Our Ref: R/131/11/NMA

**Application for a non material amendment following a grant of planning permission
R/193/10 – Hearne Court, Station Road, Rustington**

Dwg no 9312/1A

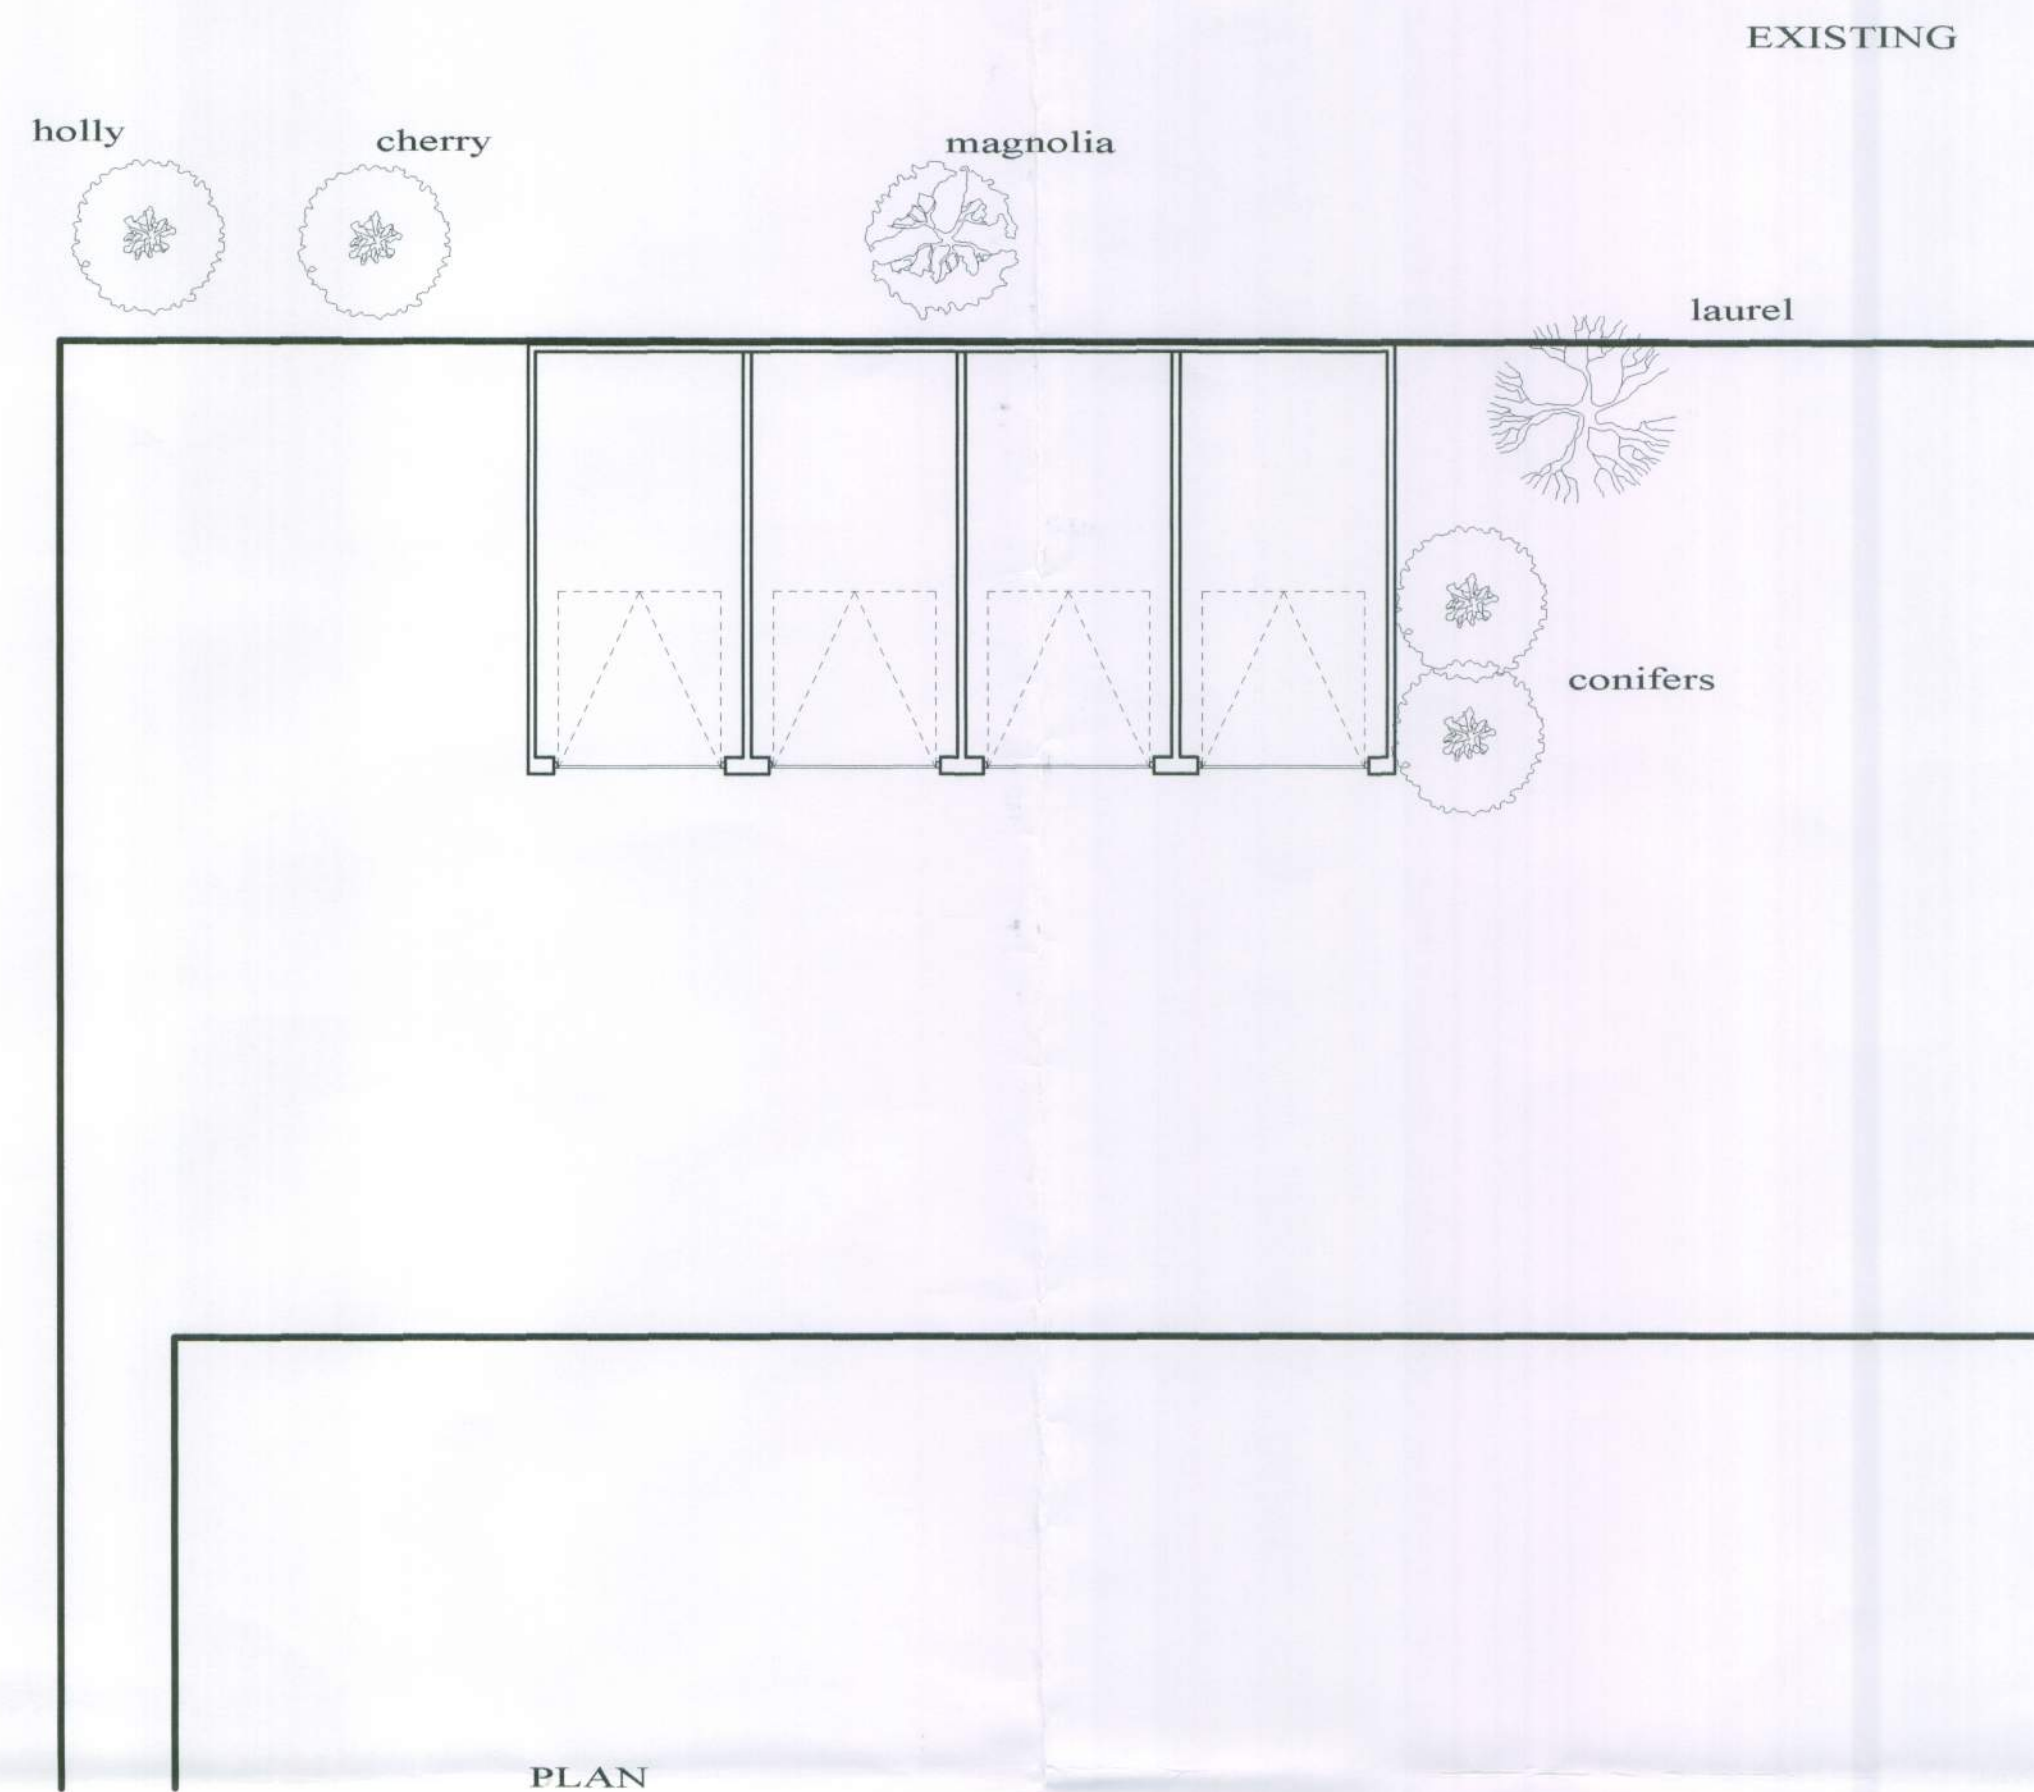
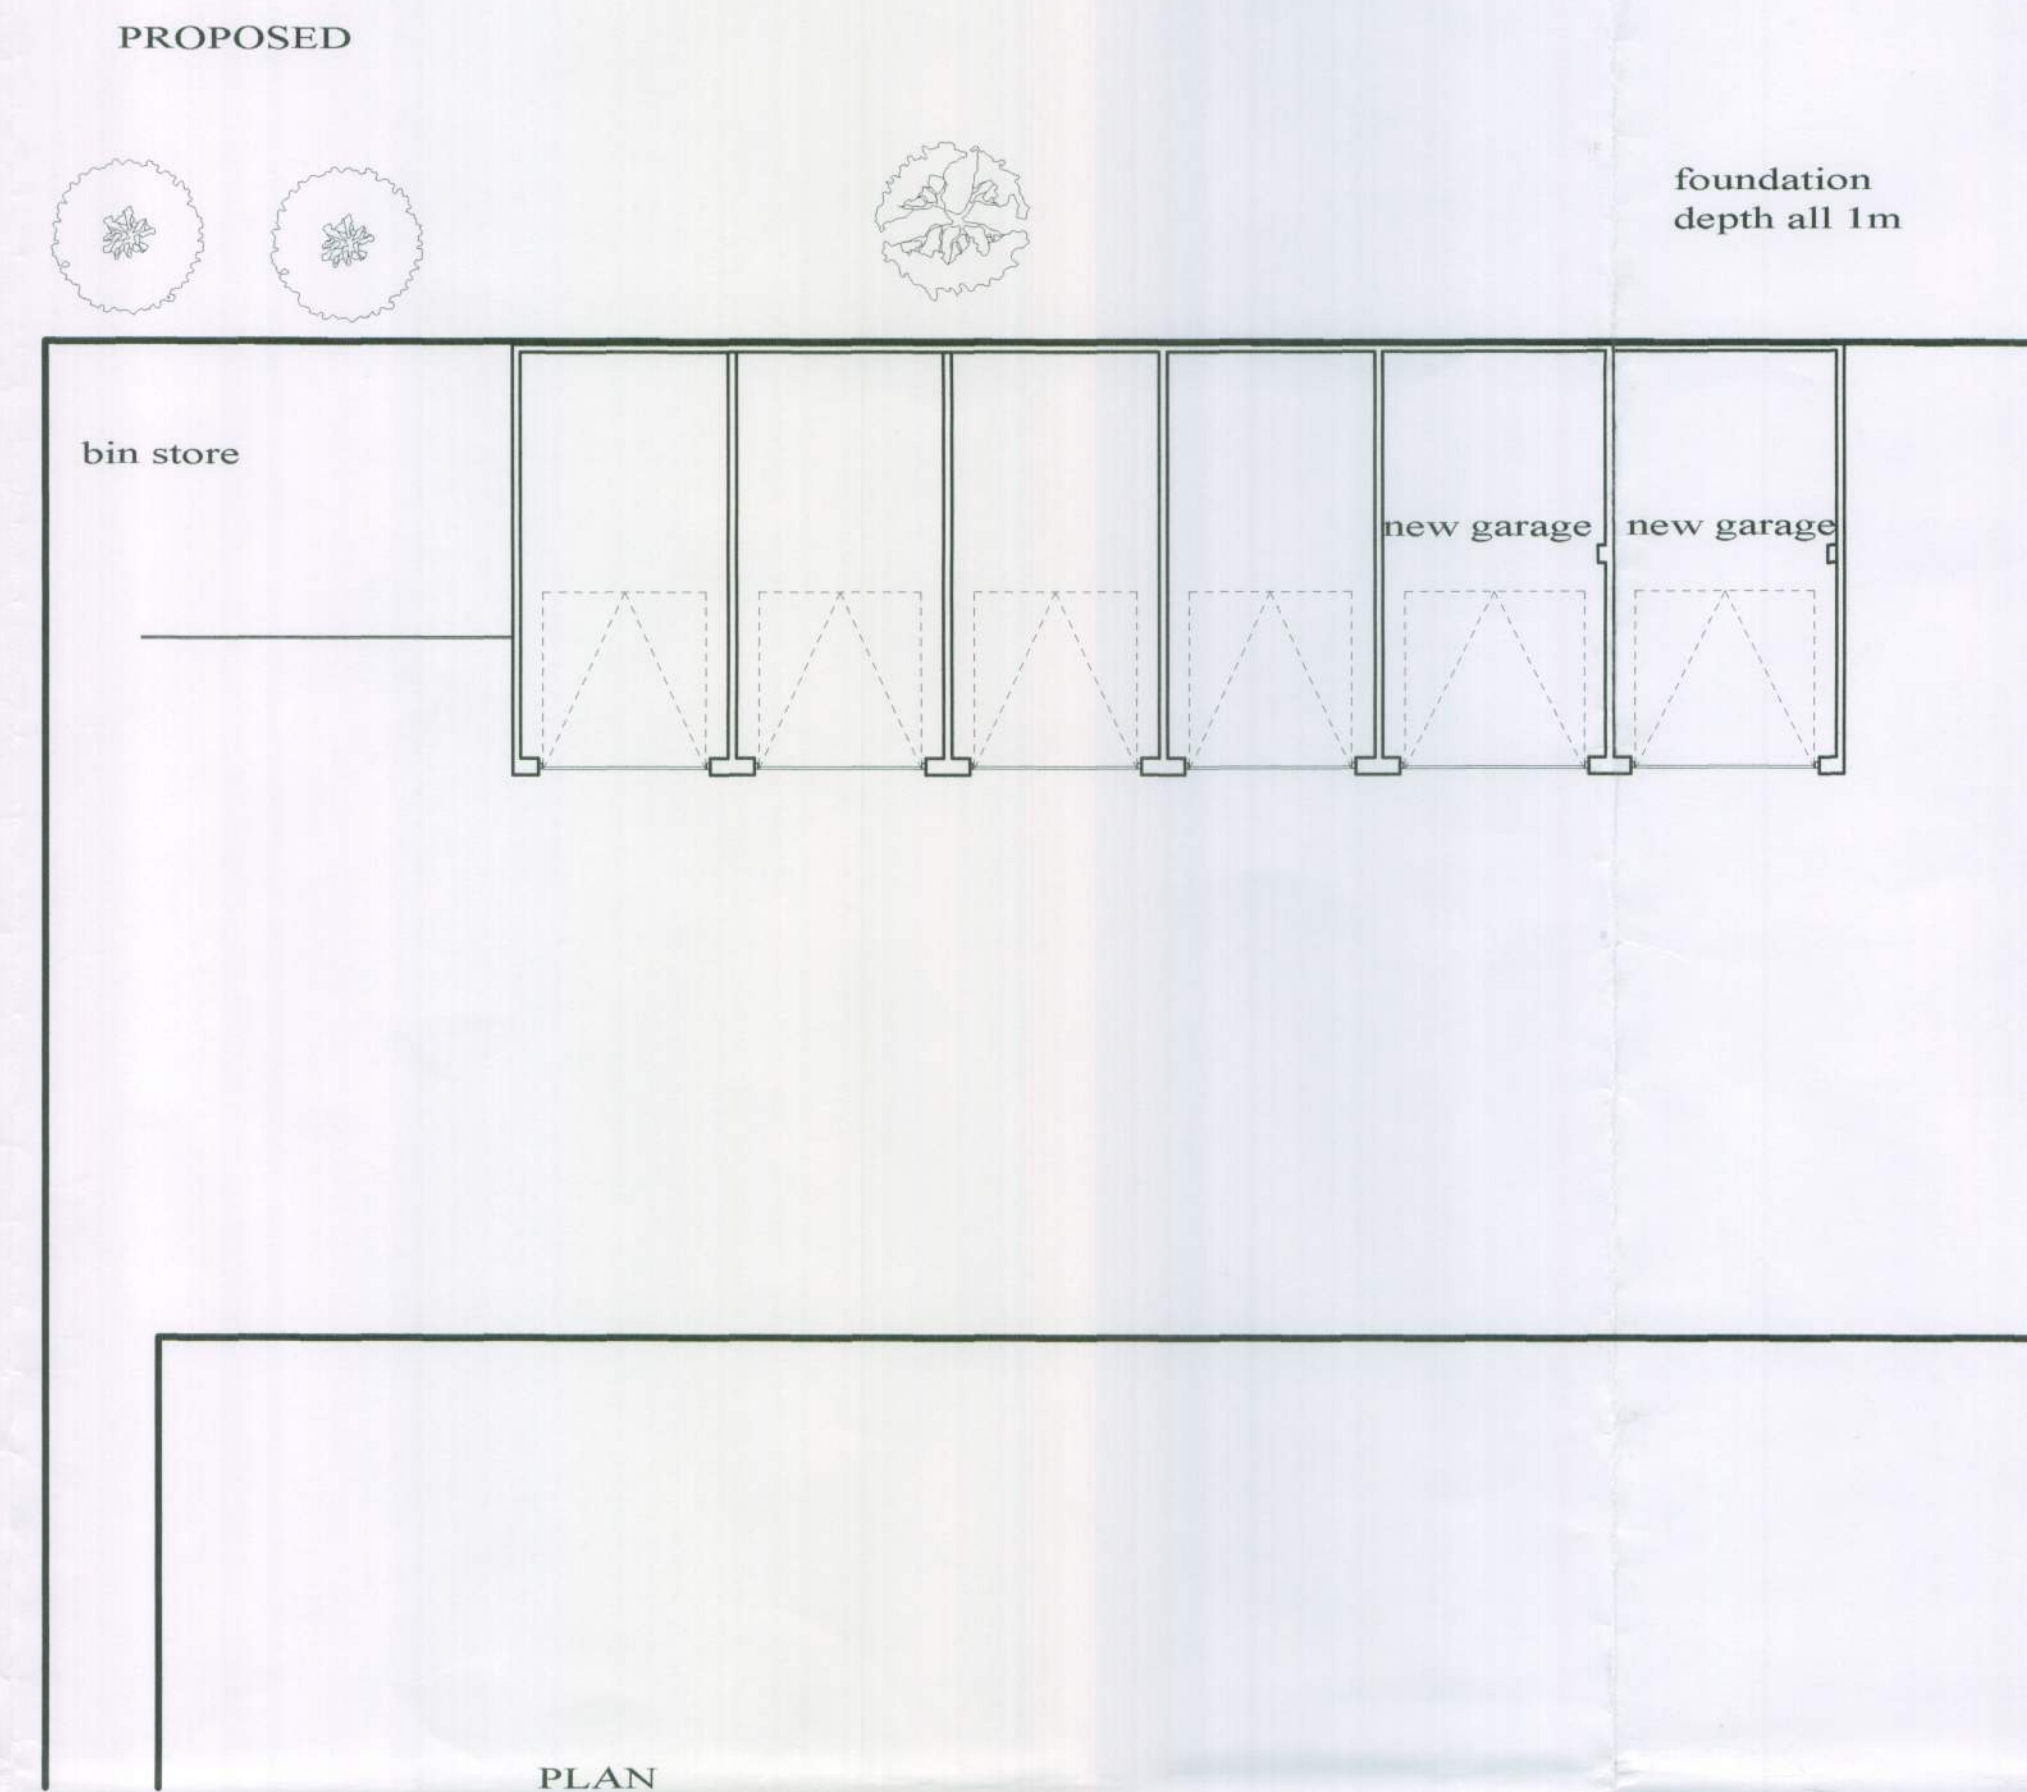
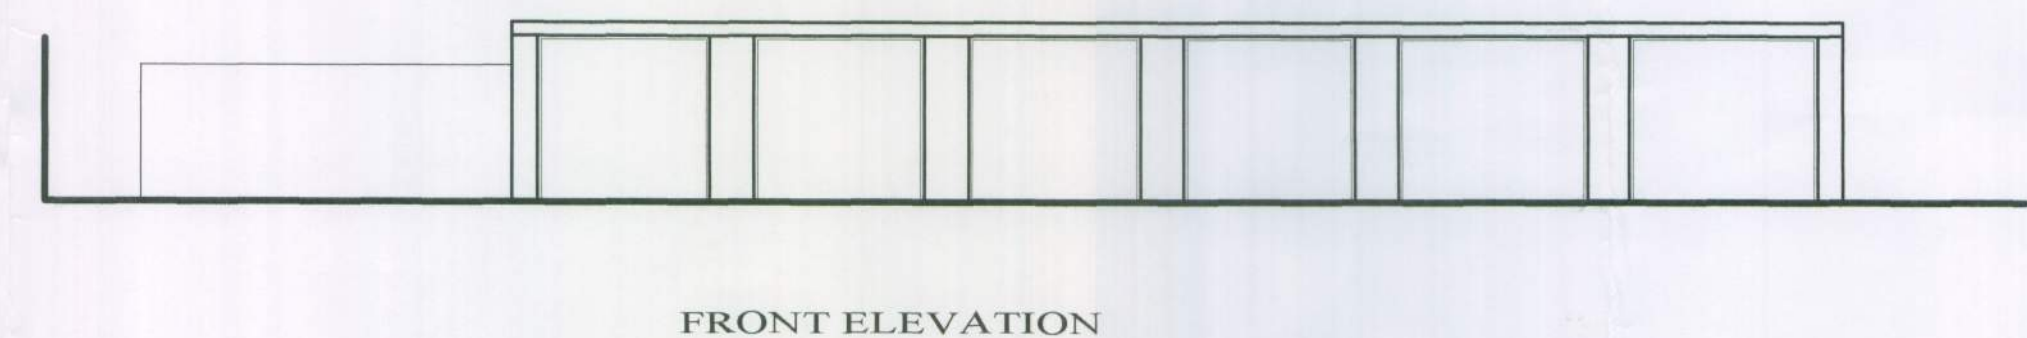
The addition change in the positioning of the garages, as shown in the plans accompanying the application can be accepted as Non-Material Amendments to the previously approved application.

Please note that the enclosed plan 9312/1A therefore becomes the approved plan for the development in so far as the positioning of the garages is concerned.
